## Connah's Quay Low Carbon Power

# Draft Statement of Common Ground between Uniper UK Limited and National Highways

Document Reference: EN010166/8.15

Revision 01

Figure 5.1 | AIL Route from Ellesmere port (Aggregate industries)

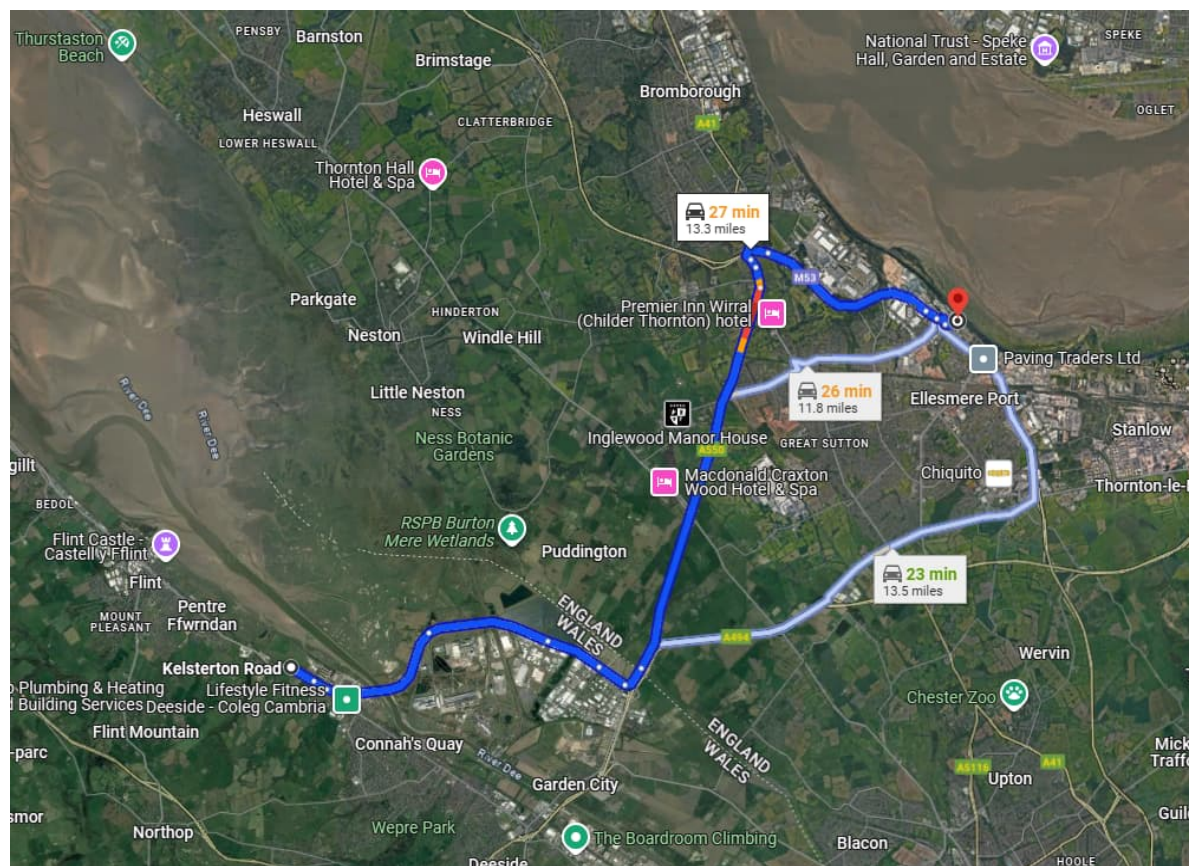
Ref	Subject	Relevant Application Document	National Highways Comment	Applicant's position	Status	Likelihood of Resolution
1.4	Consideration of the SRN – Abnormal Indivisible Loads (AIL) movements from Ellesmere Port	<b>Chapter 10: Traffic and Transport [APP-048]</b>	<b><u>National Highway's Relevant Representation (RR-025) – NH8</u></b> The exact number and size / weight of AILs would be determined at detailed design stage and would be based on specific construction methodologies that will be confirmed during this stage. Further technical assessments by specialist AIL transport contractors will be required at that stage.	The exact number and size / weight of AILs would be determined at detailed design stage and would be based on specific construction methodologies that will be confirmed during this stage. Further technical assessments by specialist AIL transport contractors would be required at that stage. An AIL Route Feasibility study (Appendix A of the <b>Framework CTMP [REP1-025]</b> ) was prepared to inform any cautions which may impact the viability of AIL route options from the point of land side delivery to the site. This study considered potential AIL movements from the three port options (Port of Mostyn, Connah's Quay Jetty and Ellesmere Port) based on the assumptions at the time of the submission.	Under discussion	High
